Date: February 13, 2023

Response to Comments

Project Name: Sather-Vaness Sewer Main
 Project File Number: PA22-048
 Review Completion: January 24, 2023 and January 18, 2023

SHEET C1 of C7
24x36
PA22-048

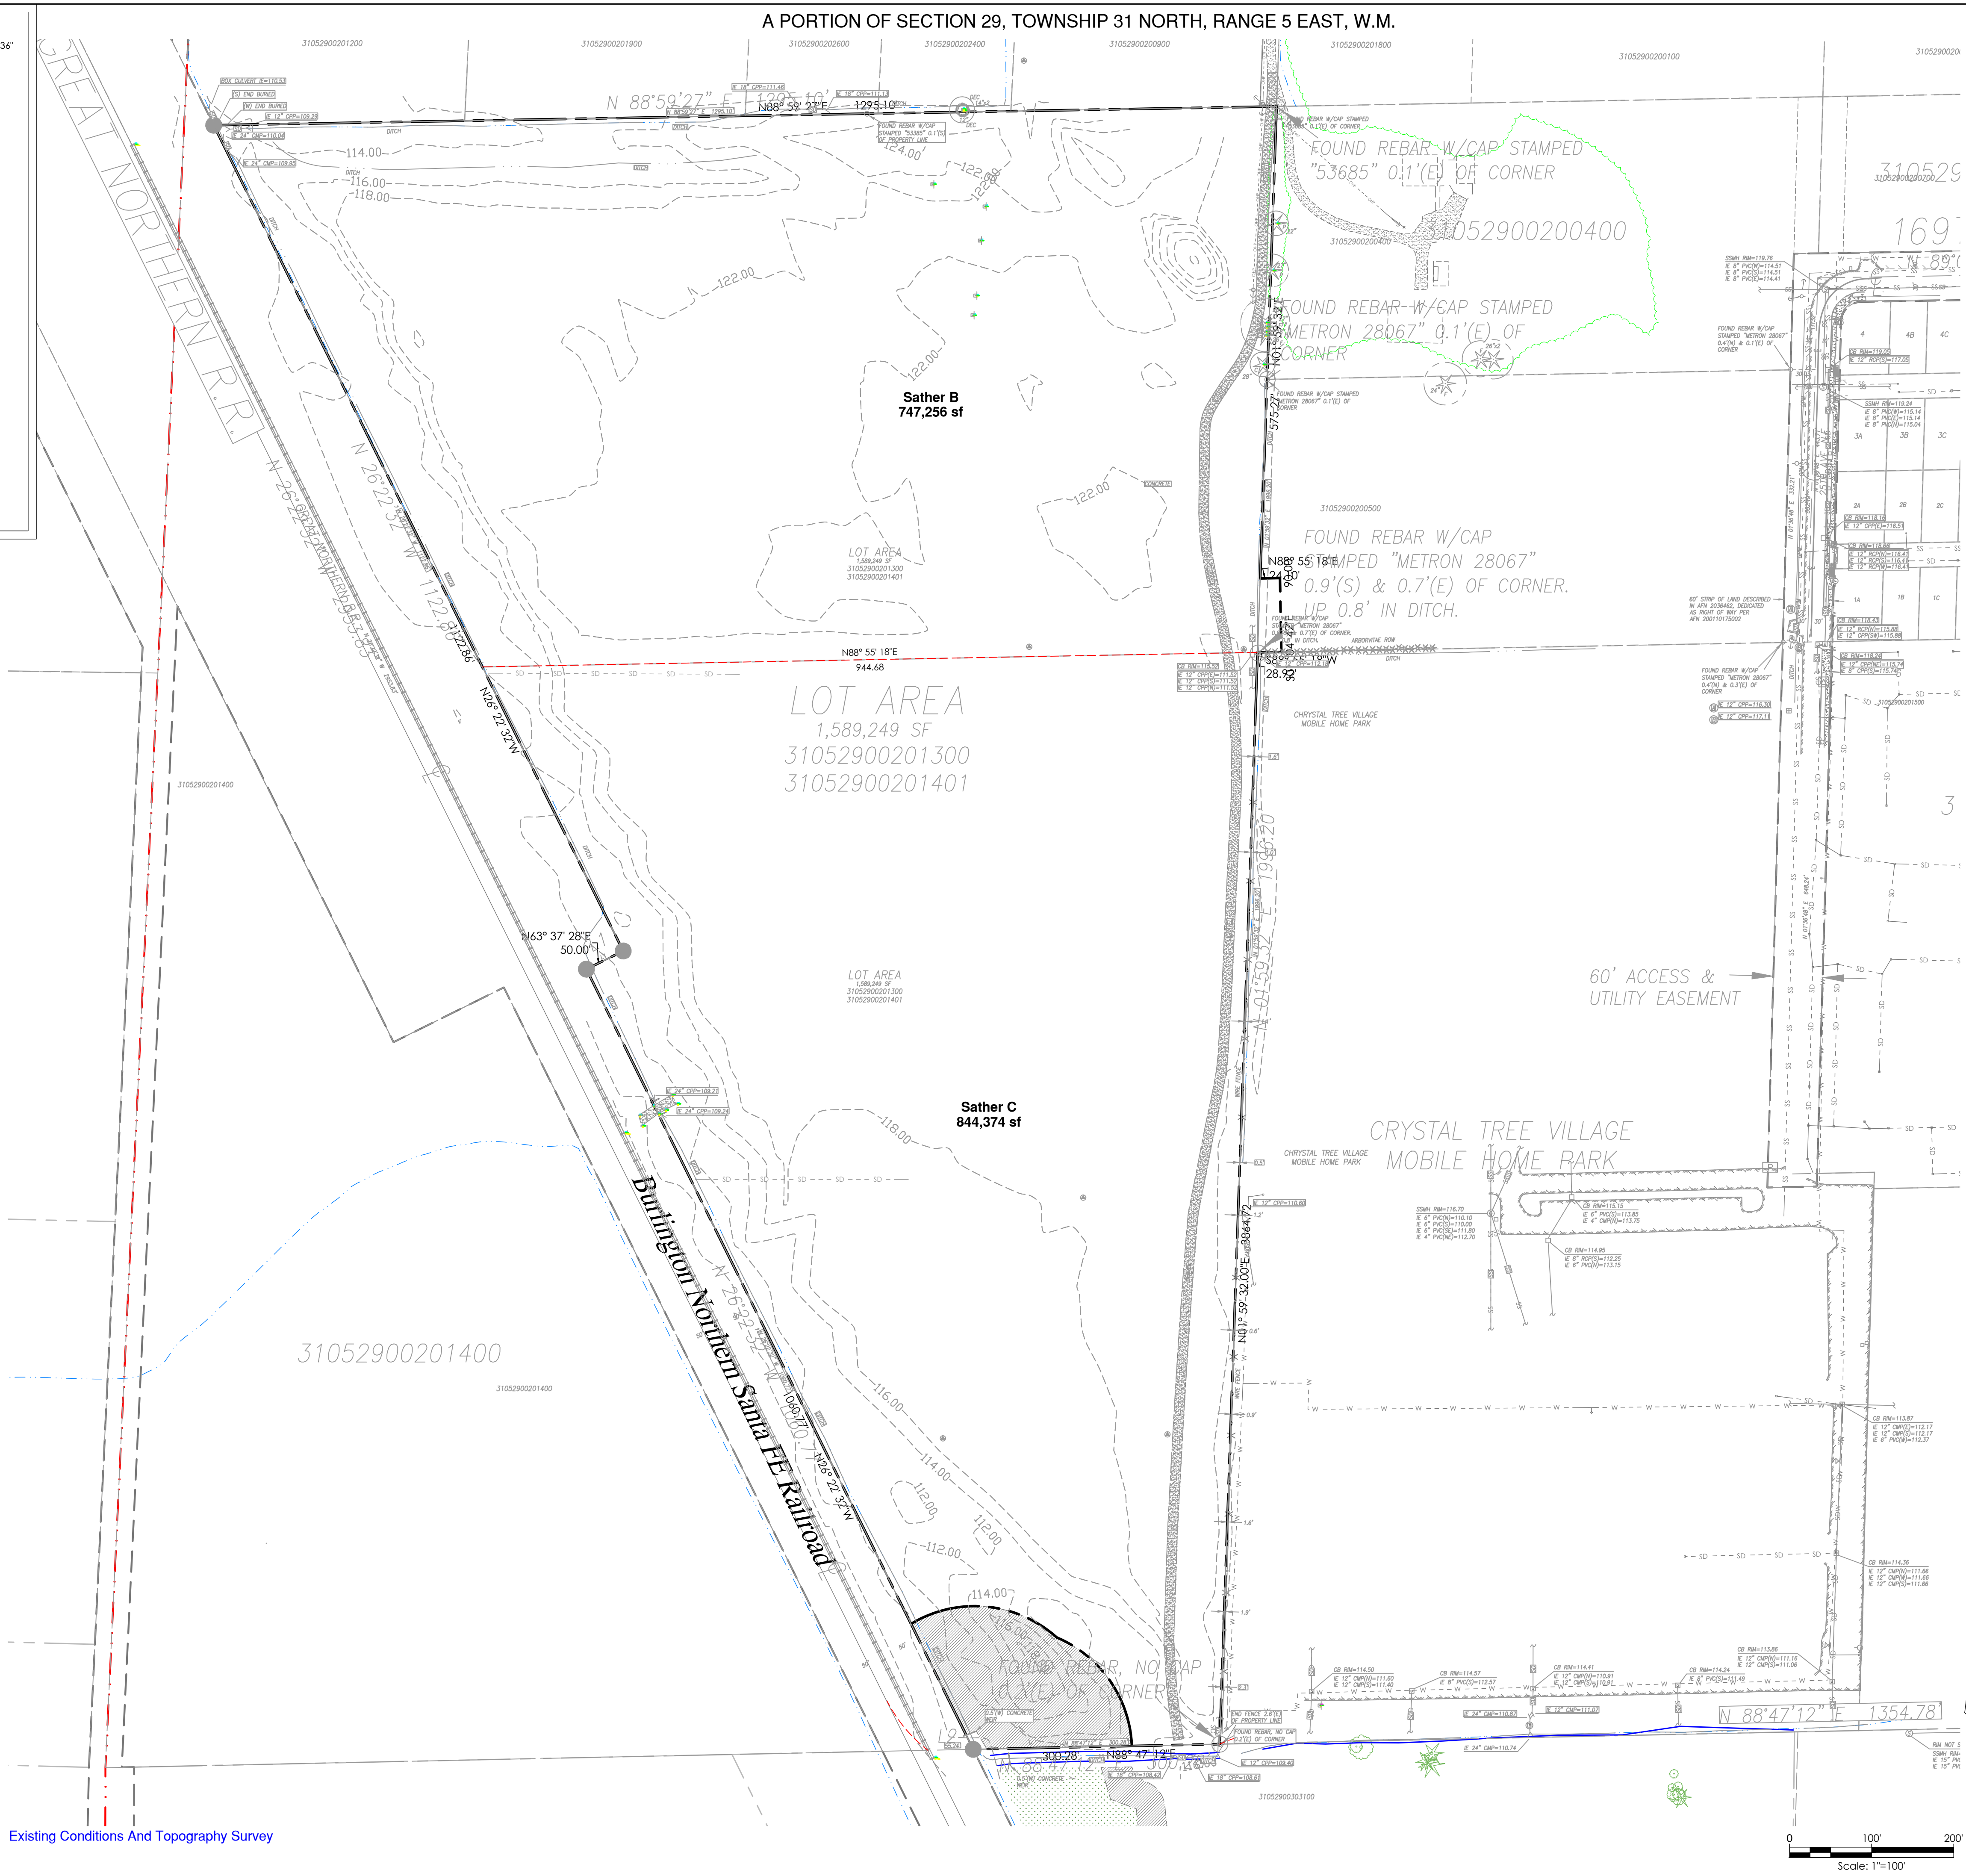
CITY COMMENTS	LAND TECH RESPONSE
Civil Plan Review: Reviewer: Shane Whitney, Civil Plan Review	
PLANSET COMMENTS	
Sheet S1	
As the main is being placed within areas that are not currently City right-of-way, we will require that easements be provided and recorded prior to completion of the project.	Easements will be provided after plan and HPA approval but before permit issuance.
Please add all applicable sewer detail drawings in the next submittal.	Sewer details have been added on S7 City of Marysville Sewer Details.

TESC

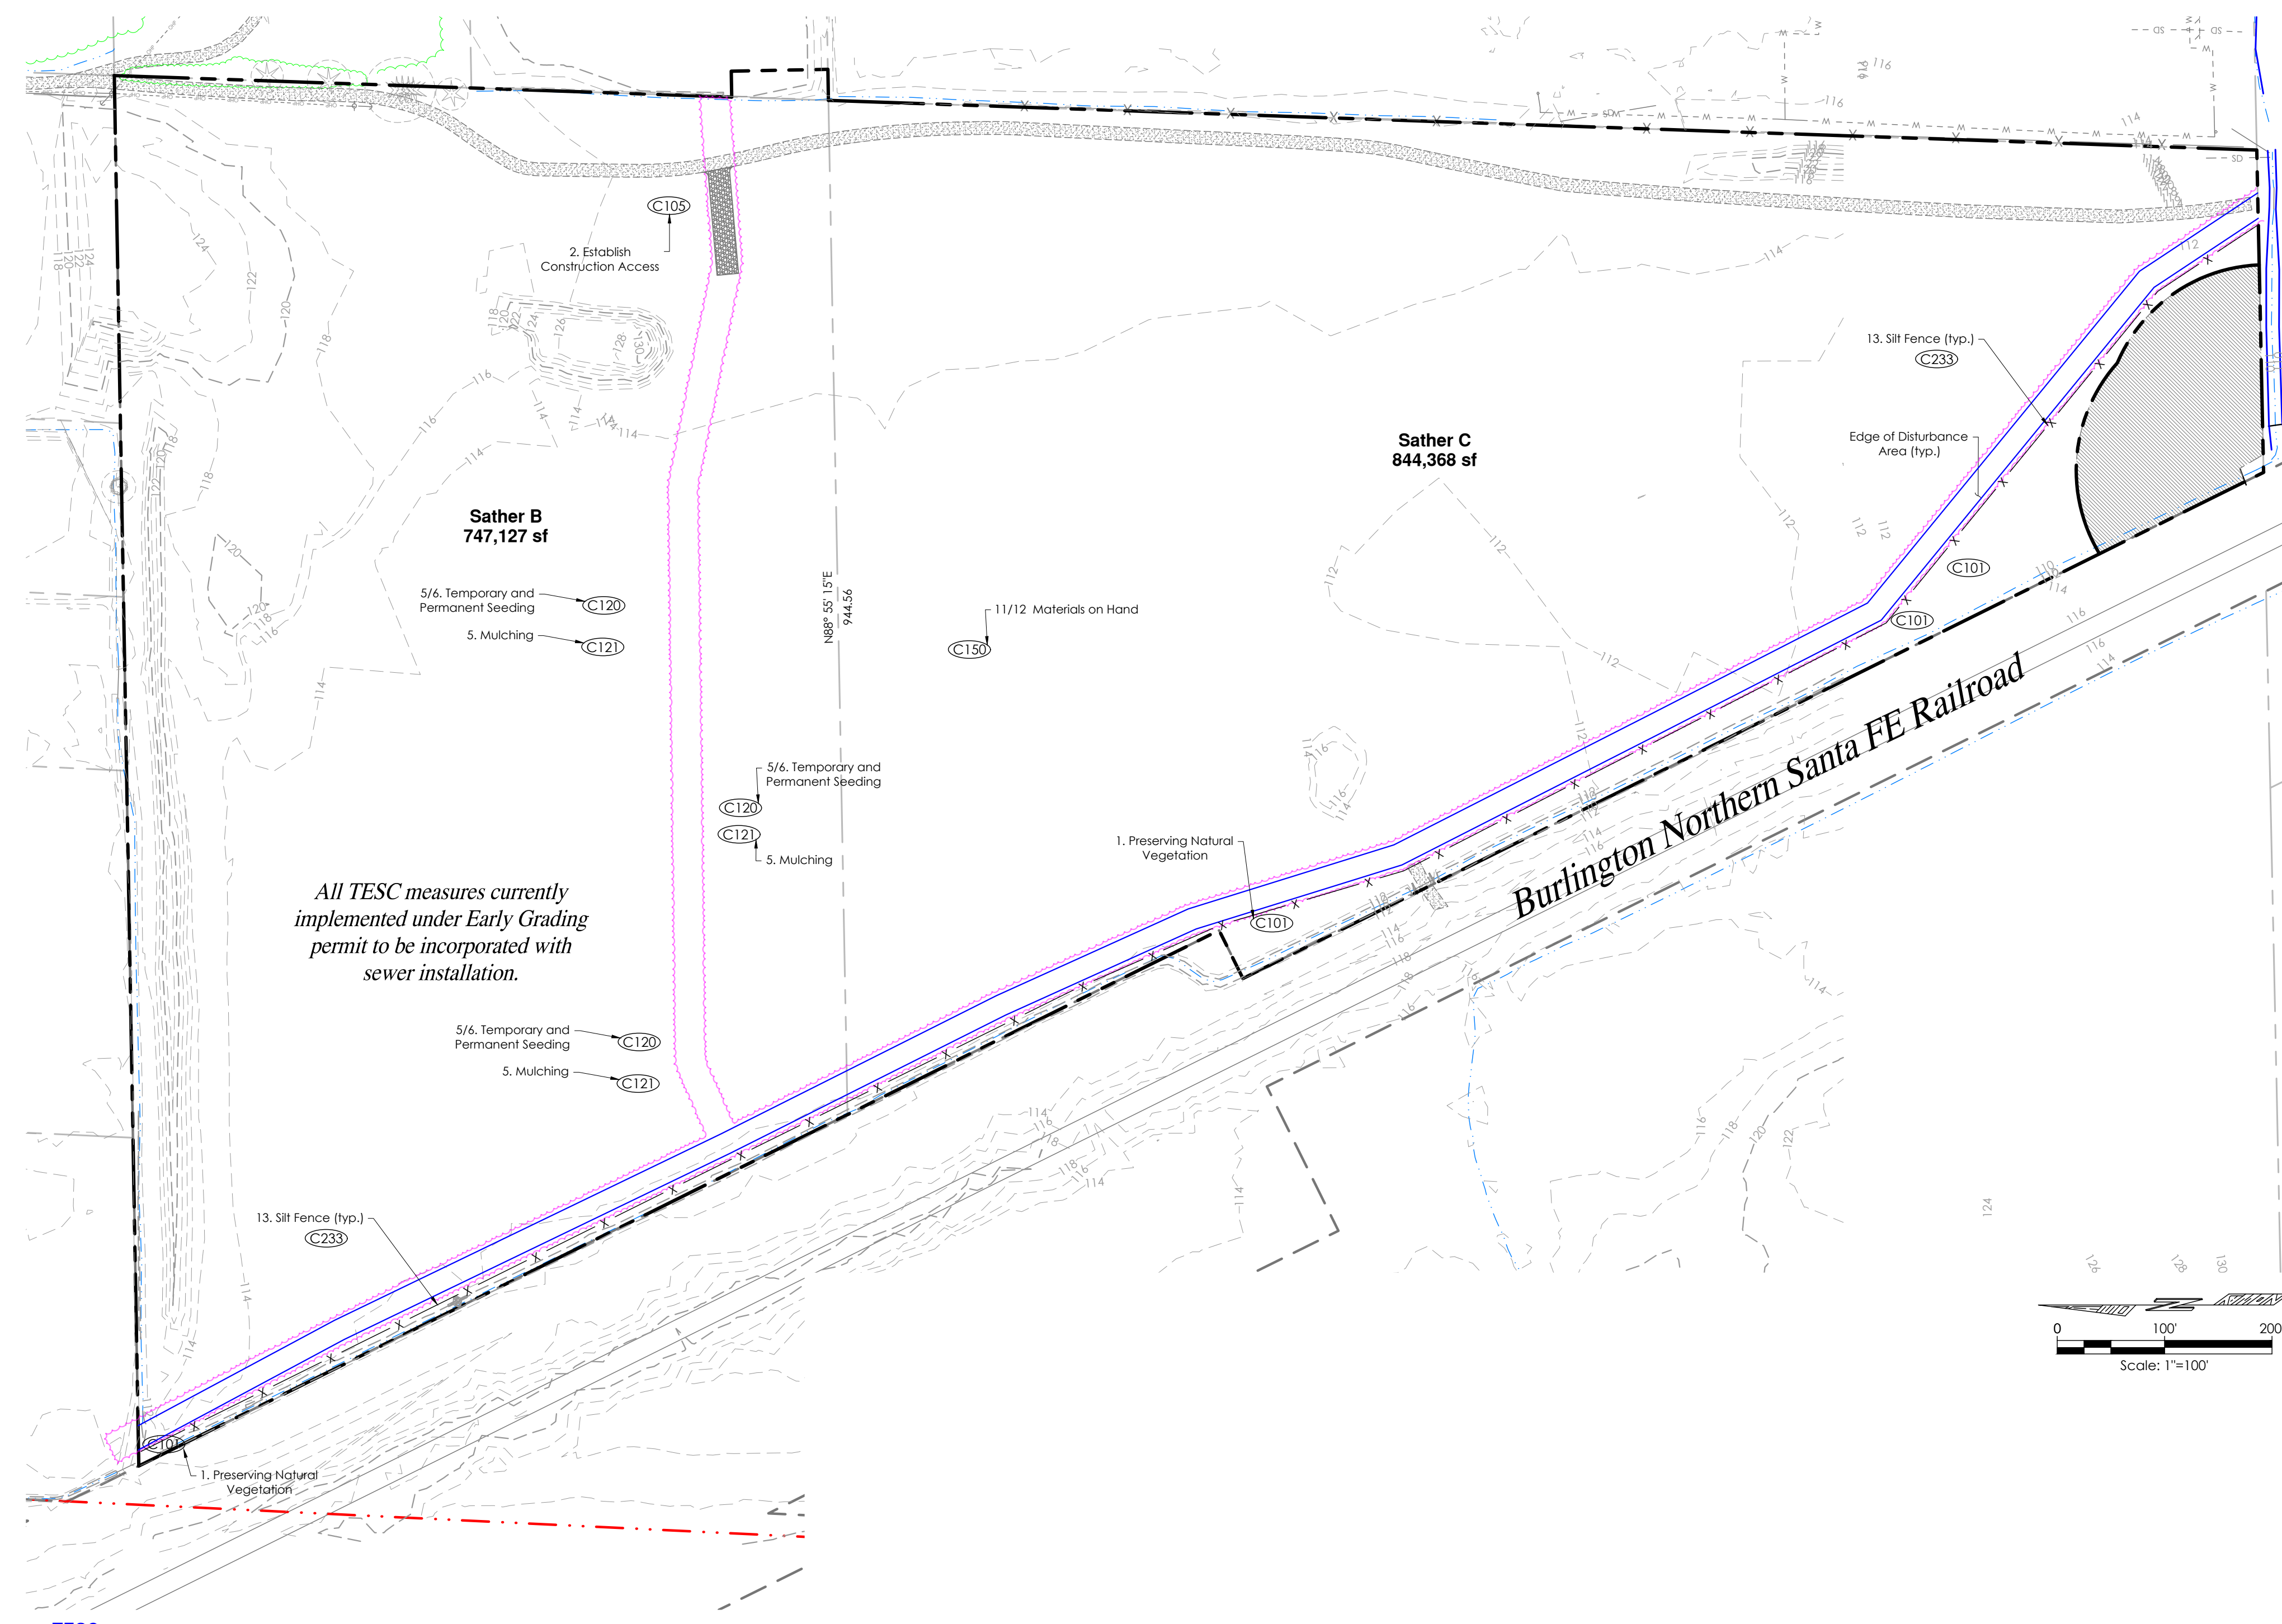
Sheet S3	
Please show silt fence in the areas where silt can either get into the ditch or back towards the mobile home park.	A silt fence has been added on C3 TESC plan.

Sewer Main Plan And Profile

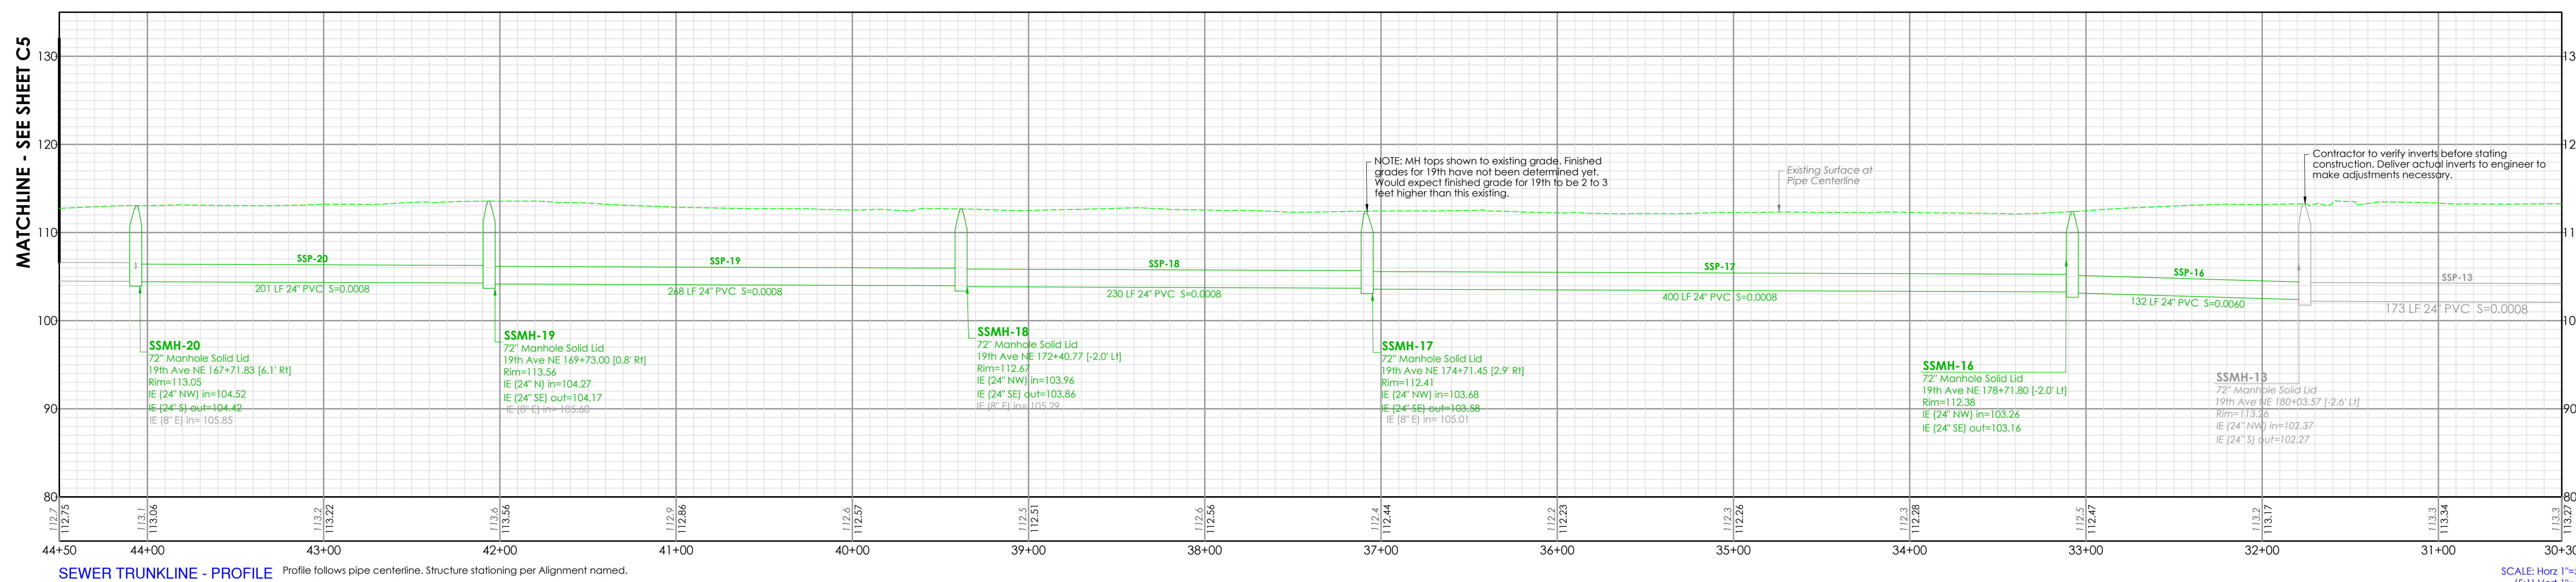
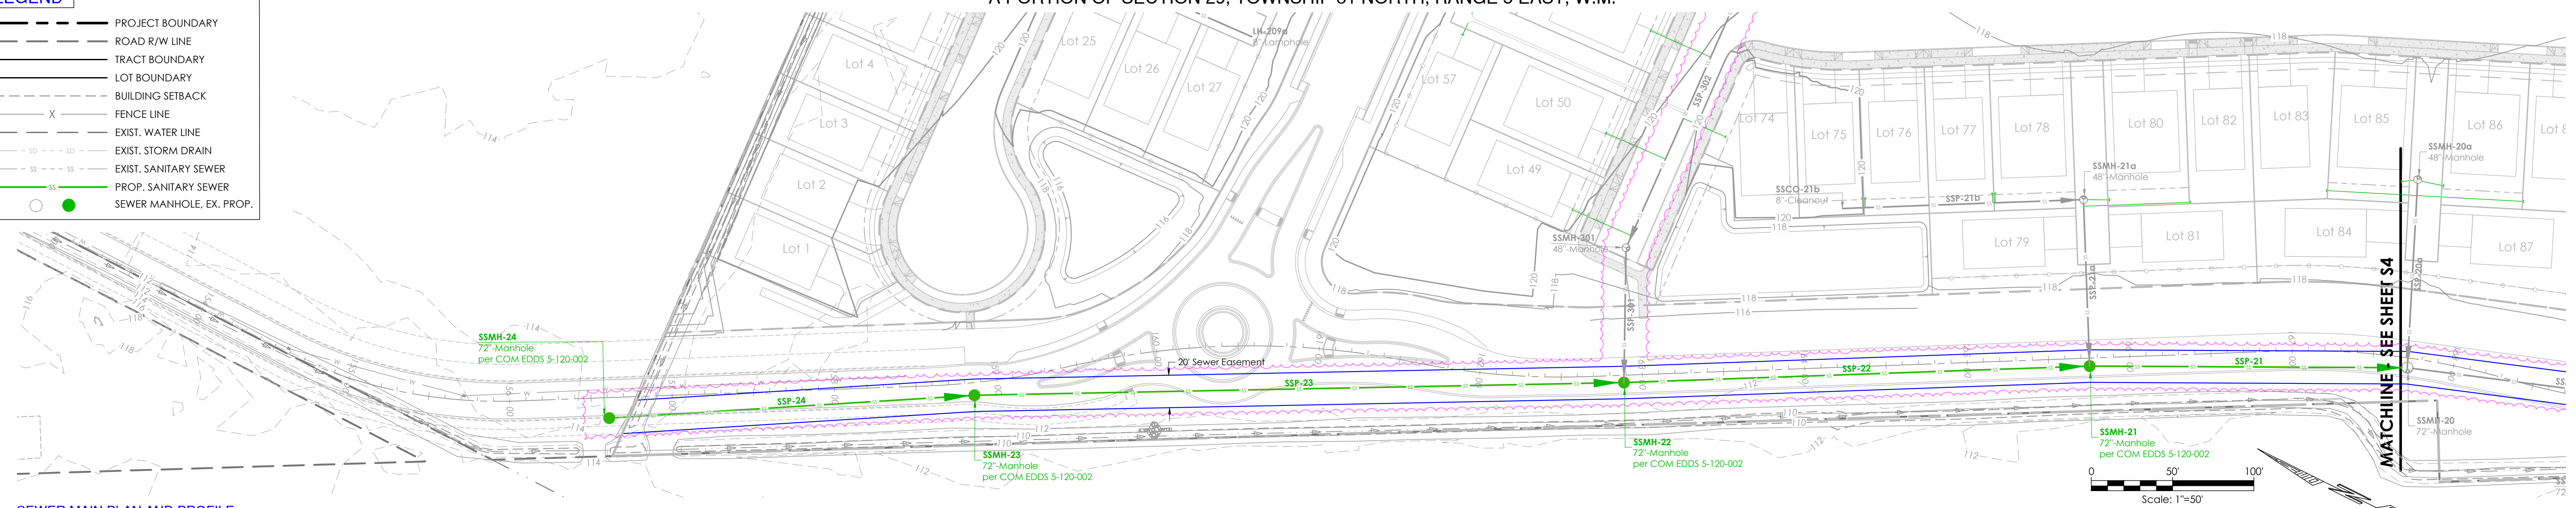
Sheet S4	
Section 5-120 of EDDS calls out that 15 to 18 inch pipe must be placed in a 72 inch manhole. Please revise	All Manholes have been updated to 72".
Please make note that the manholes in this section will be Type 3 units.	Type 3 designation is added to Manhole 801, 802 and 803.
Where we will have less than 5 feet of cover on the sewer main, the pipe will need to be C-900.	All pipe will maintain at least 5-ft of cover.
With having this structure above the planned sewer main, we'll need to have the main sleeved in this location out past the zone of influence.	Sleeve is provided to exceed 10-ft on either side of the sewer crossing. At a depth of 5-ft this would be a 2:1 zone of influence where normally only a 1:1 is required.
